**KIRKLEES METROPOLITAN COUNCIL
INVESTMENT & REGENERATION SERVICE**

Reference No:	2024/70/90888/W
Site Address:	Reap Hirst House, Reap Hirst Road, Birkby, Huddersfield, HD2 2DD
Description:	Variation of conditions 2. (plans) & 3. (spiral spring balance mechanisms) on previous permission no. 2023/91257 for Listed Building Consent for demolition of existing conservatory, and erection of single storey extension, new rear entrance canopy, replacement windows and door and reintroduction of mullions and chimney, minor external modification and internal modifications of modern partitions
Recommending Officer:	Sue Brooks

**DECISION - Grant Consent for Variation of Conditions 2 and 3 of
Application 2023/91257**

| 3536 (0-1) 05                                                    |       | D          |

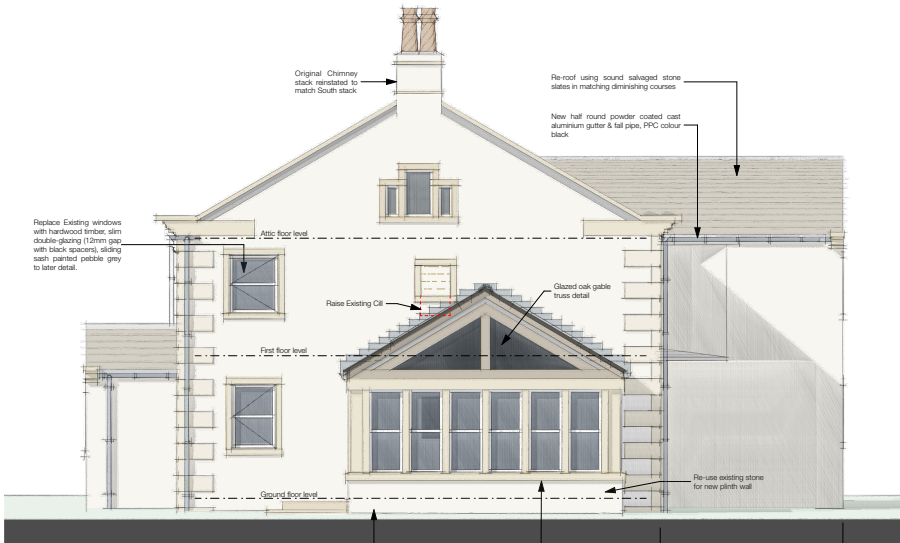
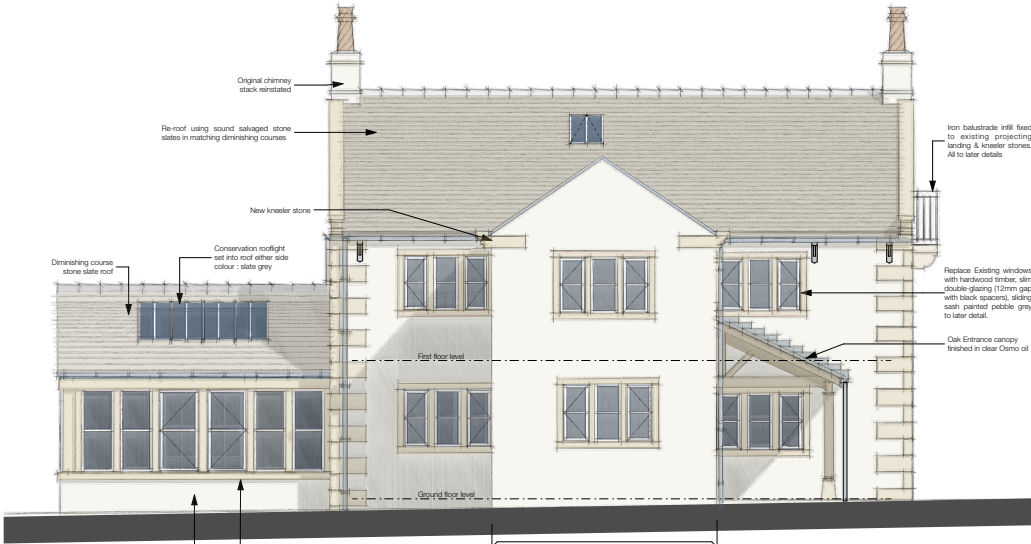
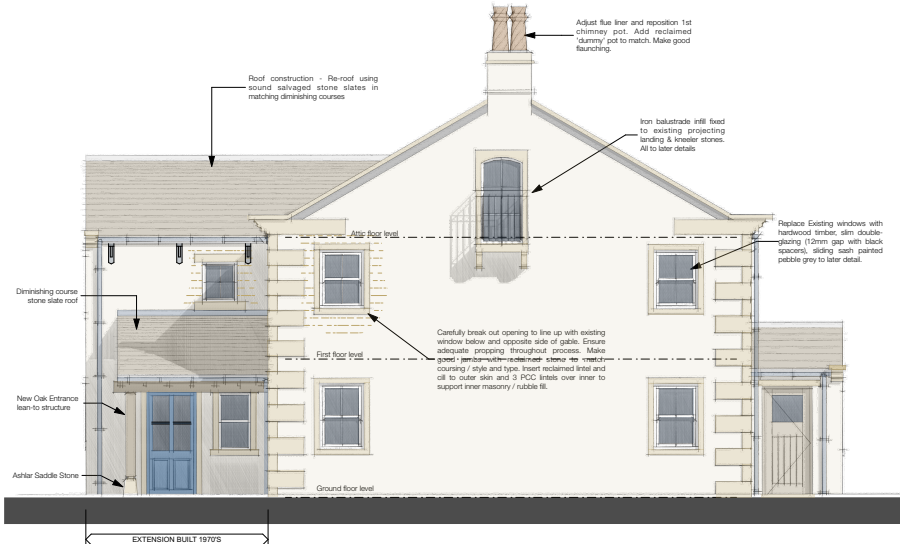
The revised proposed drawing 3536 (0-) 05 revision D includes an iron balustrade on the ledge outside the second-floor gable window. This is the subject of Condition 4 of application 2023/91257 and the agent has confirmed that a separate discharge of condition application will be submitted.

This variation of condition seeks to amend the approved elevation drawing 3536 (0-) 05 Rev C and substitute it with drawing 3536 (0-) 05 Rev D. The amendments are to remove the proposed stone finials from the approved drawing and change the proposed sliding sash windows on the north and west elevations of the main house and the proposed conservatory for casements and fixed lights with horizontal glazing bars.

Two stone finials were shown on the approved drawing 3536 (0-) 05 Rev C, located on the two-storey extension and modern porch. As there are no historic precedents for finials on the building their omission is acceptable.

The existing windows are uPVC, and prior to this they were timber framed fixed lights and casements fitted prior to the date of listing. An archive image submitted with the approved application shows that the windows on the front (east) elevation were historically small sliding sashes and fixed lights with glazing bars, set into mullioned openings. This variation on condition application proposes to retain the approved sash windows on this principal elevation and the prominent south elevation, reinstating the historic window types as evidenced in the archive image, with no replacement or loss of historic fabric. Timber framed fixed lights and side hung casements are now proposed on the other elevations and the modern conservatory, reinstating the type in place at the time of listing, albeit with the introduction of horizontal glazing bars to reflect the configuration of the new sashes.

The proposed variations outlined above will have a neutral impact on significance and have no impact on the historic fabric and are therefore acceptable.

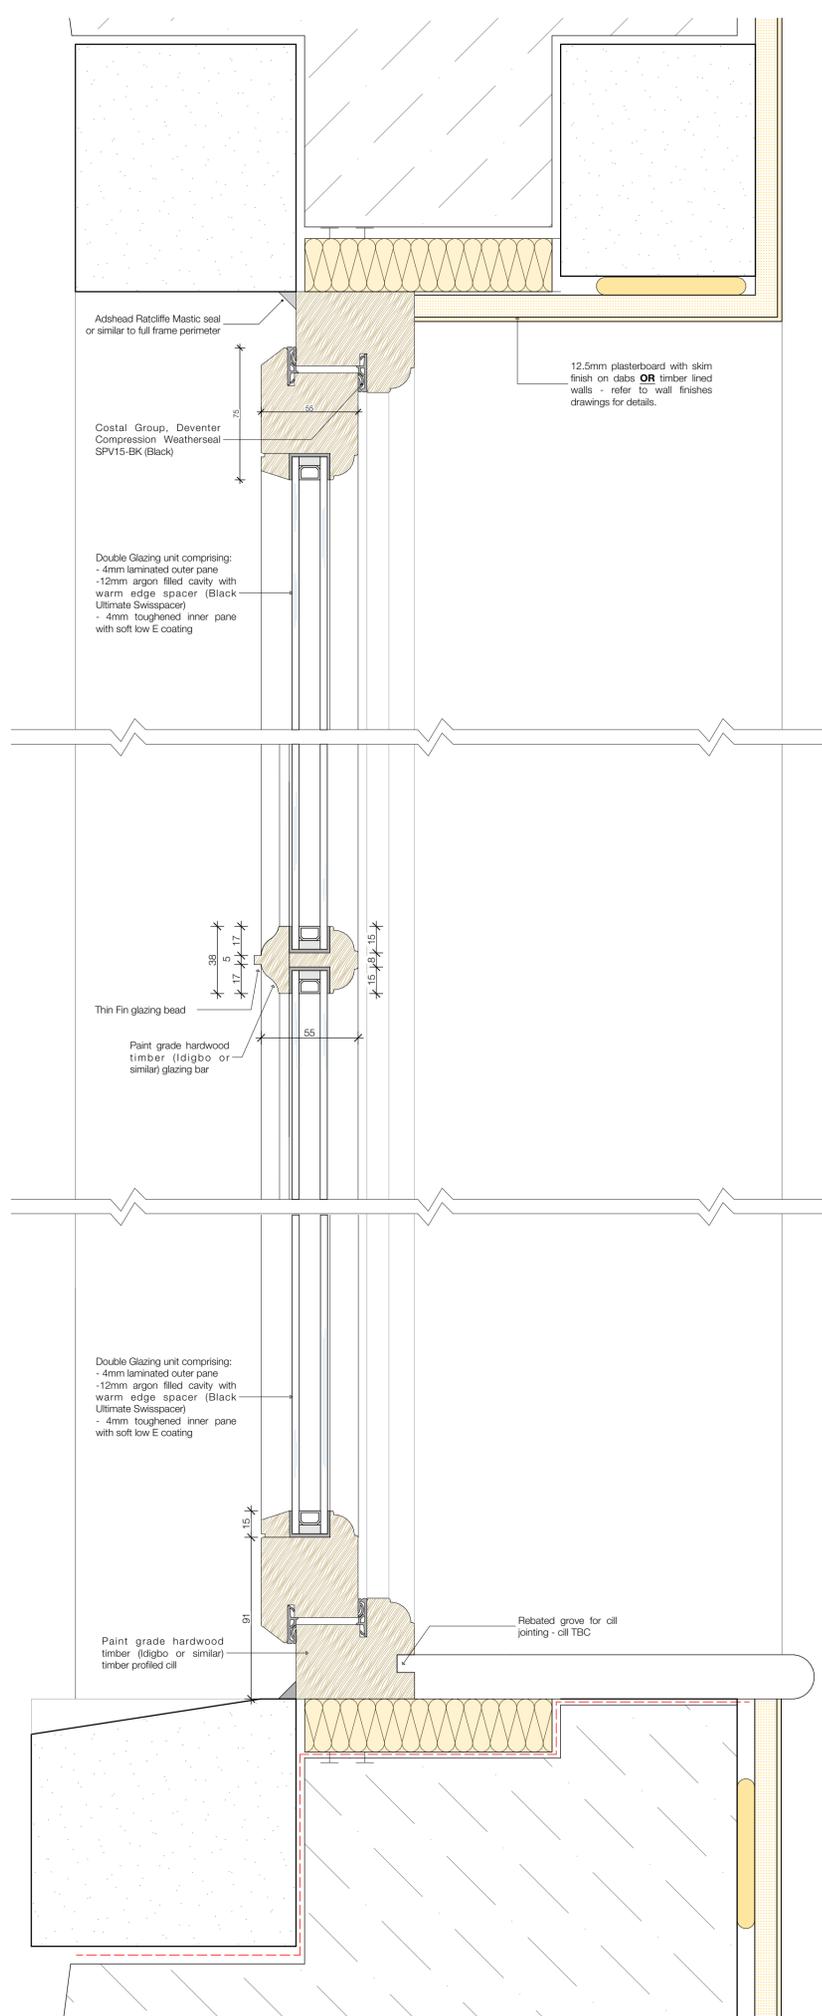
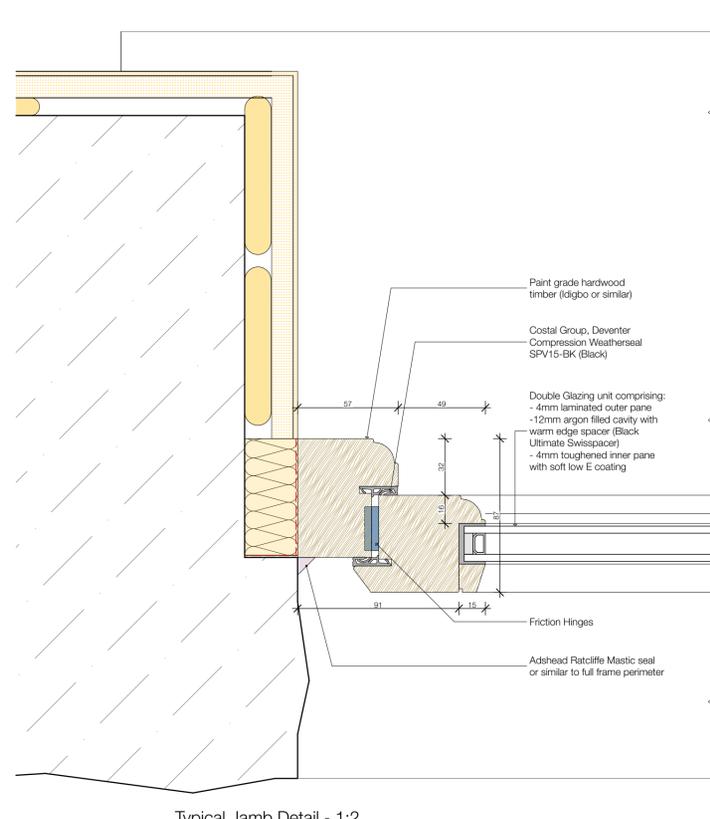
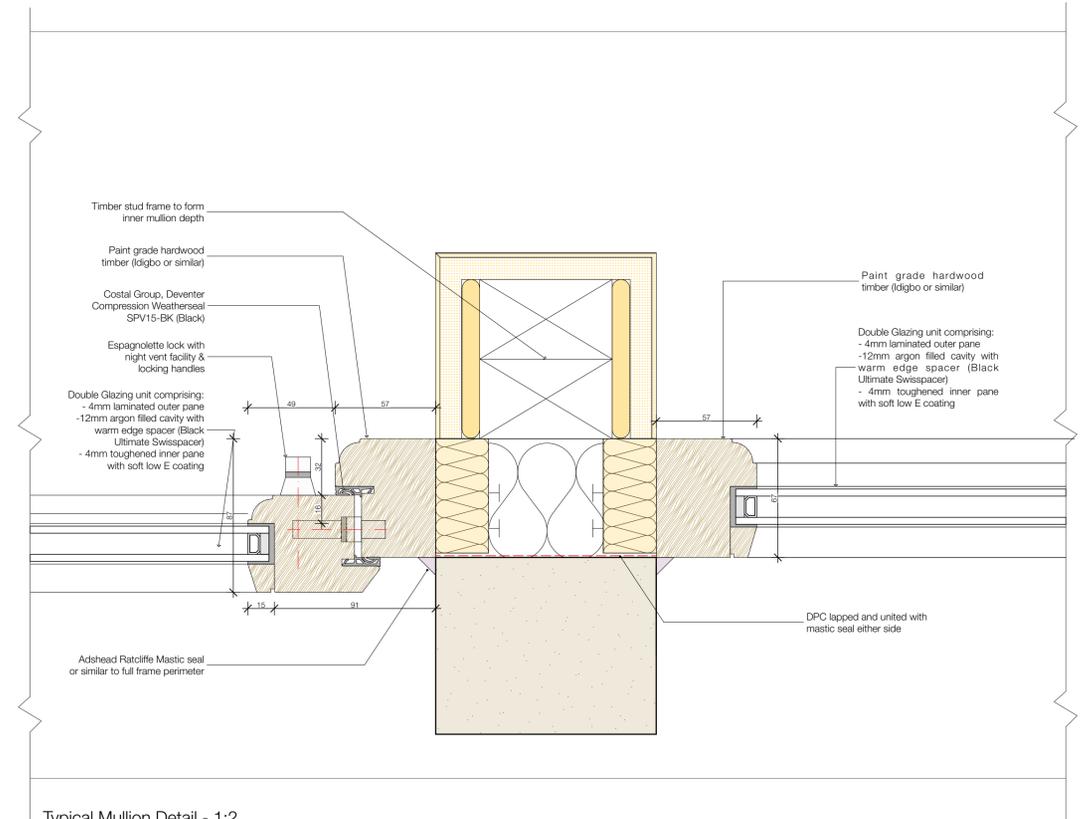
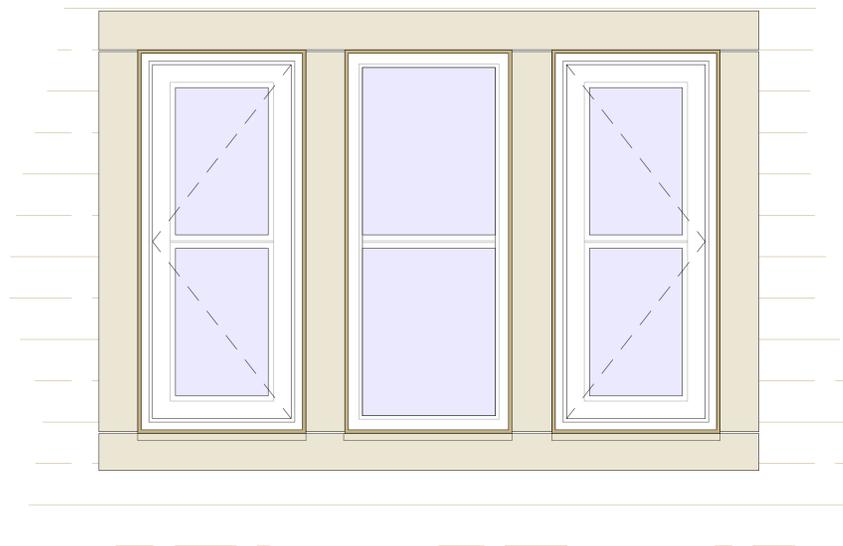
Timber casement and fixed light window joinery detail drawings were requested and submitted.

4. Notwithstanding the information submitted, new casement windows and fixed lights shall be hardwood timber double-glazed with a pebble grey painted finish. All slim double-glazed units shall have 4mm glass with a 12mm gap using warm black spacer bars. Opening casements shall have butt hinges and traditional window stays (friction hinges shall not be permitted) and all new window frames shall be set back in the reveal by 100-125mm and not fitted flush with the external wall. Visible trickle vents shall not be permitted. Obscured glazing shall have a plain etched finish and not be in patterned glass.
